**EXHIBITION OF EA: CONSTRUCTION OF BUILDINGS 6, 9, 10 & 17 (STAGE
2 RESIDENTIAL DEVELOPMENT) AT 61 MOBBS LANE, EPPING –
MP11_00478**

I refer to your letter dated 8 August 2011 regarding the above application. The Department of Transport (DoT) has reviewed the *Environmental Assessment* and provides the following comments:

1 GROUND FLOOR PLAN
1 : 100

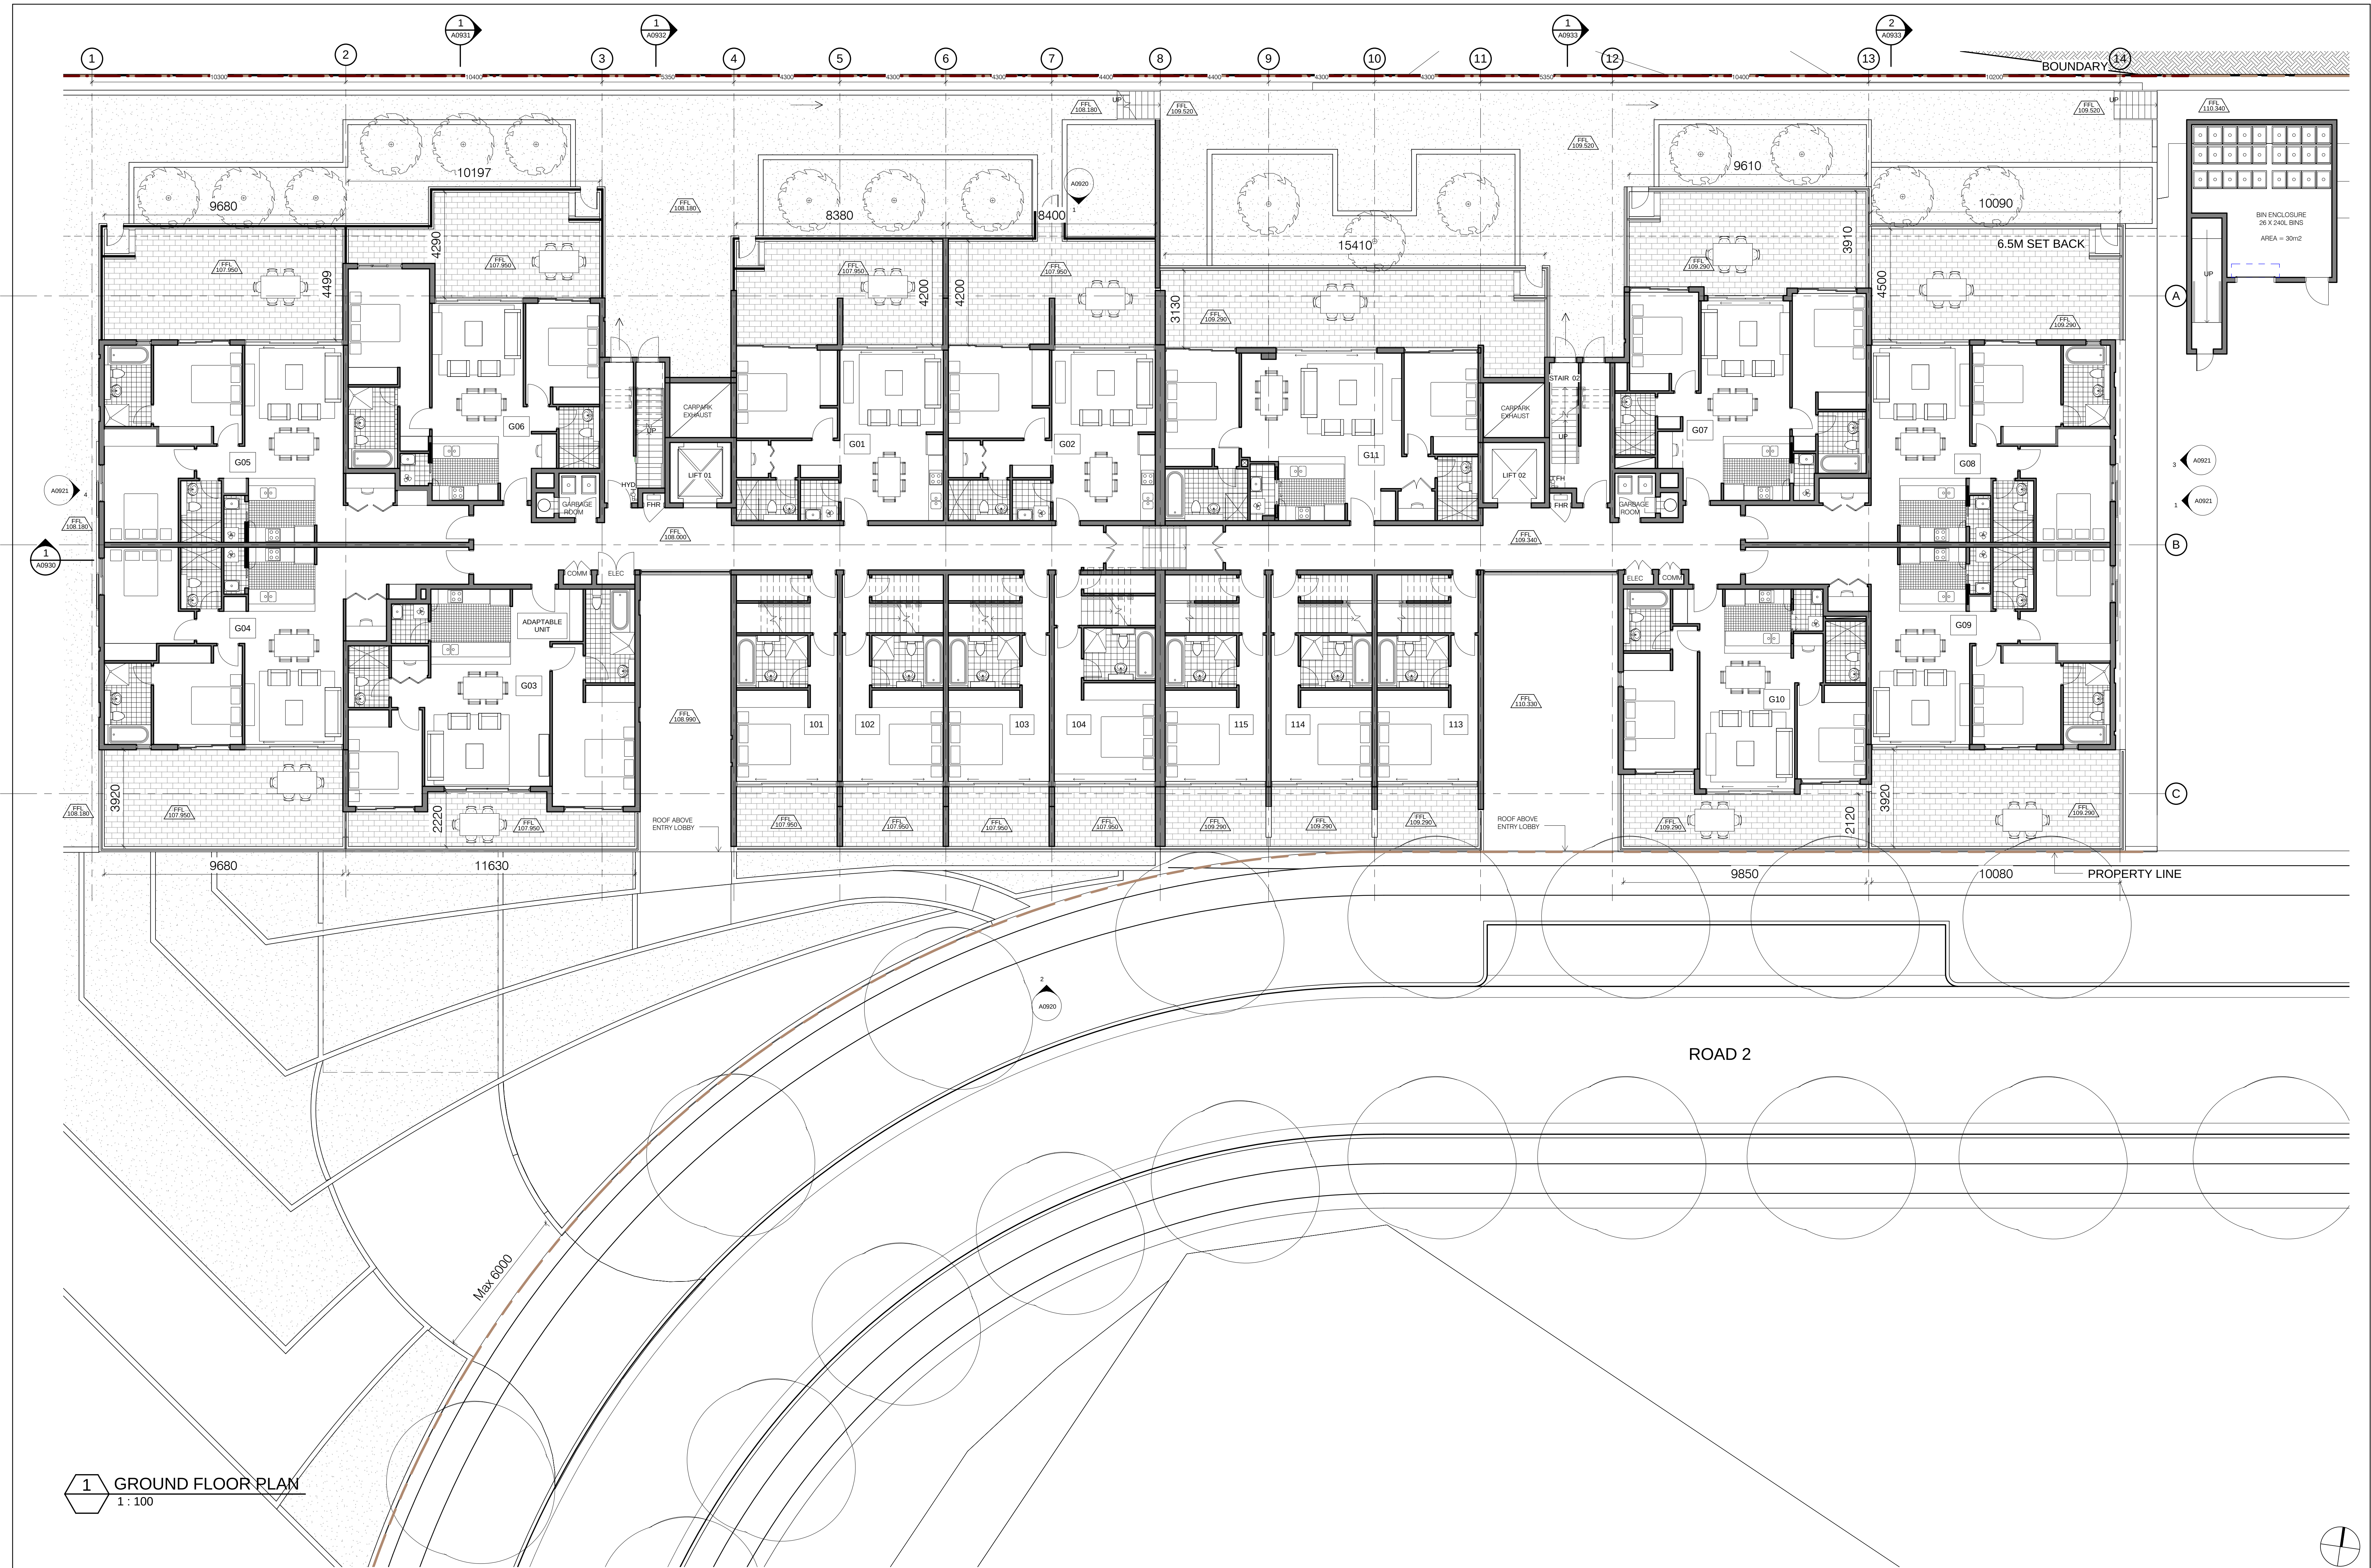
- DoT notes 75 bicycle parking spaces are proposed in the basement levels. In addition to these spaces, DoT supports the inclusion of bicycle parking at-grade for visitors to site. These facilities should be in a weather protected location, near entrances and subject to casual surveillance. This should be included as a condition of consent; and
- DoT supports the development of a Travel Access Guide (TAG) for residents to encourage public and active transport use. Further information on TAG resources can be found at the Road & Traffic Authority's website, <http://www.rta.nsw.gov.au/>. This measure should be adopted as a condition of consent to be prepared prior to the issue of the occupation certificate for each building.
